Subject: Integra Coal Project, Section 75W Modification Application

Glencore apologises for this administrative error and requests the Minister or delegate to modify the Project Approval by replacing the current inaccurate Project Layout Plan included in Appendix 3 of PA 08_0101 with the two Project Layout Plans contained in **Attachment C** to this letter.

APPENDIX 3: PROJECT LAYOUT PLANS

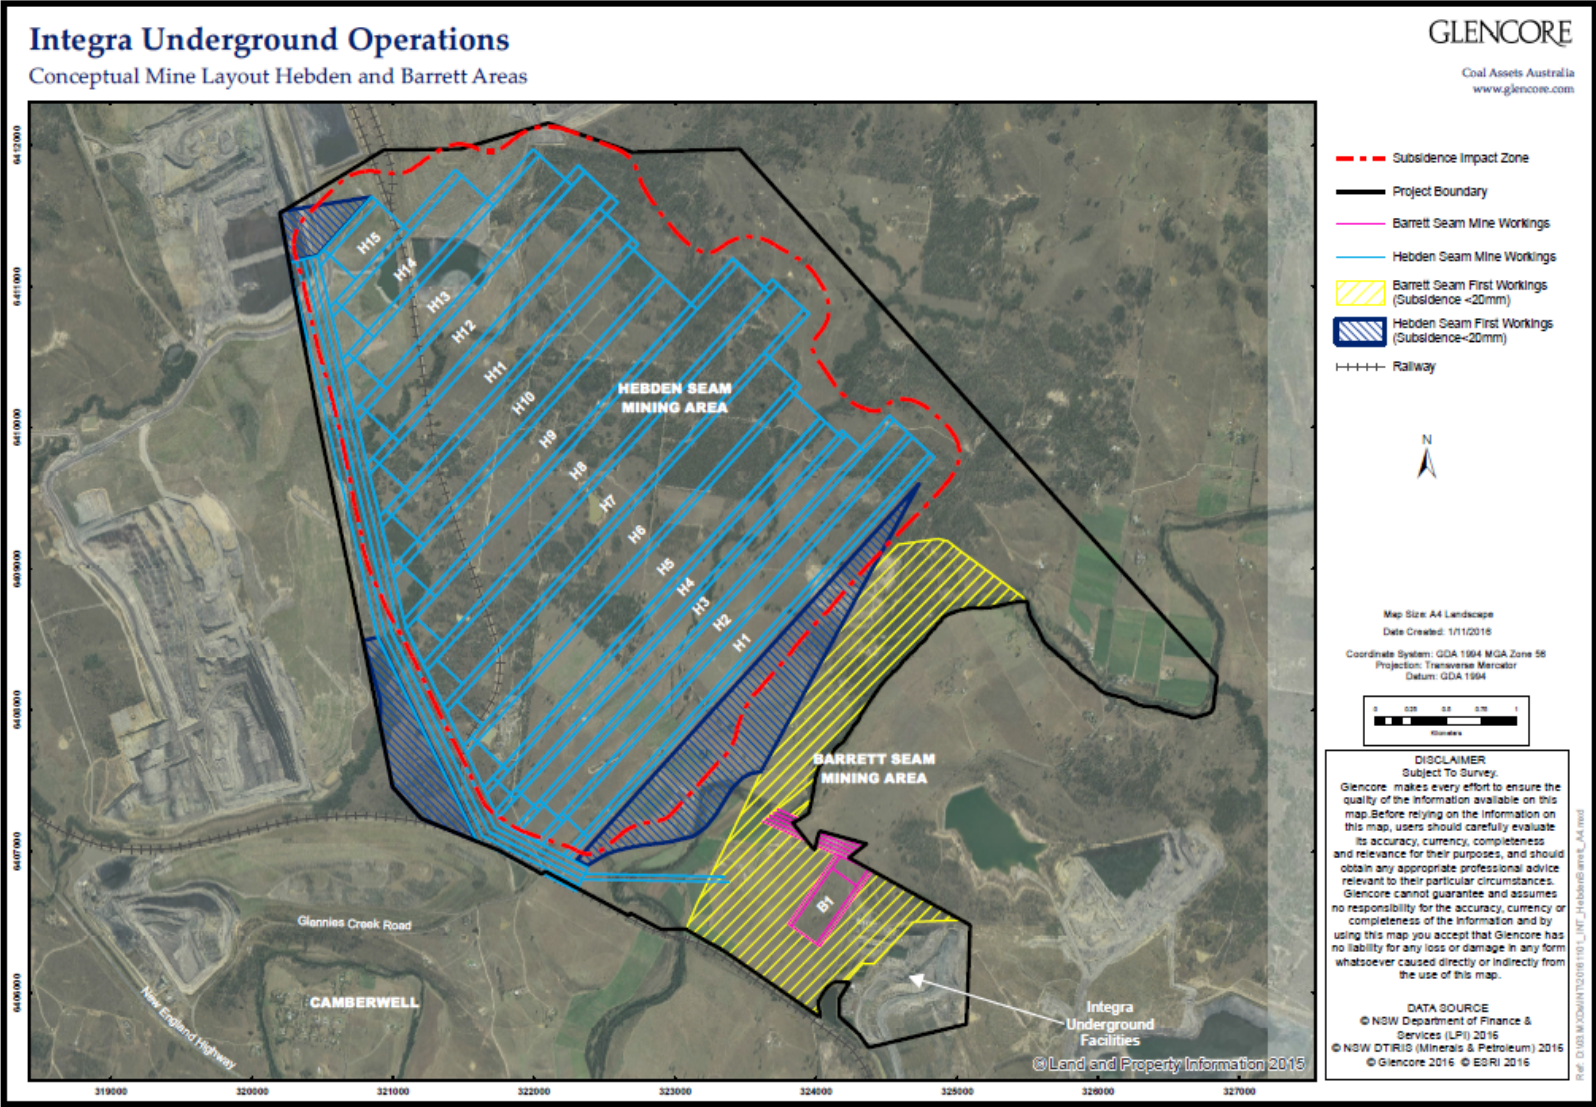
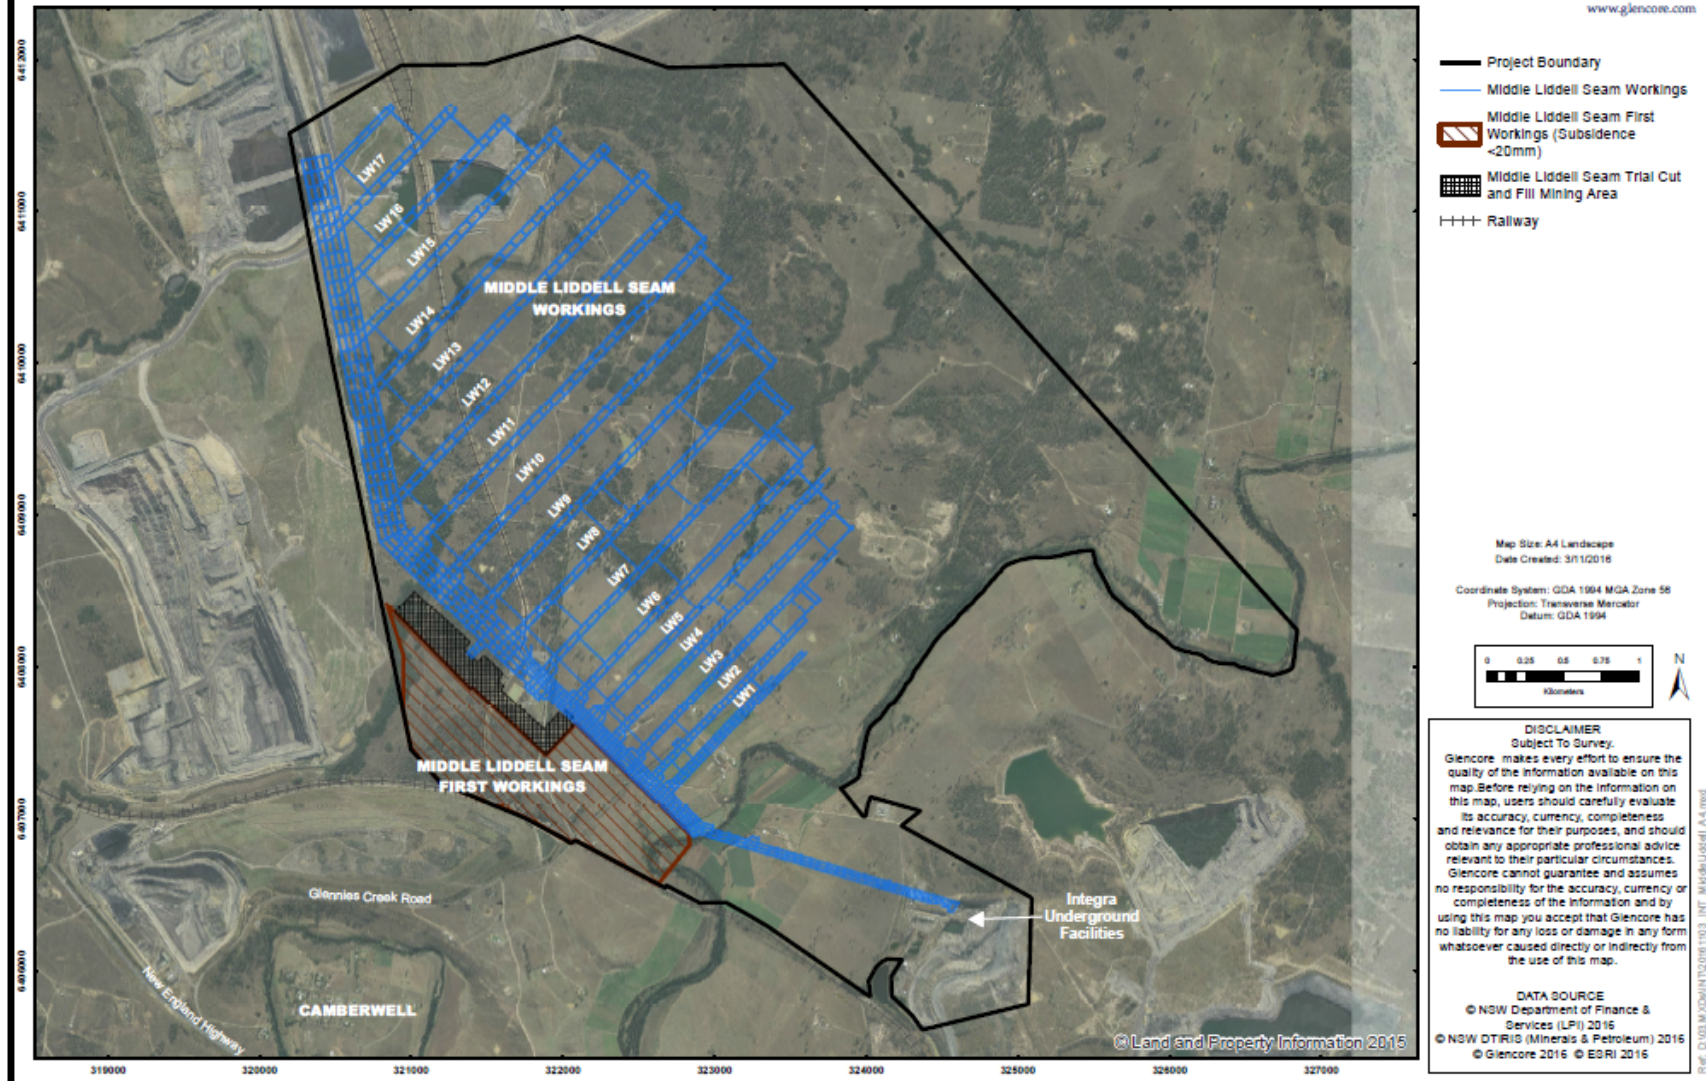
Following determination of Modification 5, PA 08_0101 now contains a single Project Layout Plan in Appendix 3, a copy of which is provided for reference as **Attachment A**. It has come to Glencore's attention that this plan, provided by HVCC to DP&E is incorrect. The incorrect plan was provided as a result of an administrative error on Glencore's behalf.

Glencore advises that, due to this administrative error, the current single Project Layout Plan in Appendix 3 of PA 08_0101 is not an accurate representation of the current approved mine plans for the Integra Underground Project which were previously shown on the Project Layout Plans that were set out in Appendix 4 of the Project Approval, prior to it being separated as a result of Modification 5.

As discussed above, HVCC requests the Minister or delegate modify the Project Approval to replace the current Project Layout Plan (PA 08_0101 Appendix 3) with the Project Layout Plans provided in **Attachment C**.

The modification sought by this application is administrative in nature only and the replacement Project Layout Plans are entirely consistent with the Project Layout Plans that were previously included in PA 08_0101 (prior to Modification 5), with the exception of the Project Boundary which has been adjusted to account for the fact that some of the mining lease area has been transferred to Bloomfield and now forms part of the Integra Open Cut Project and is no longer part of the Integra Underground Project.
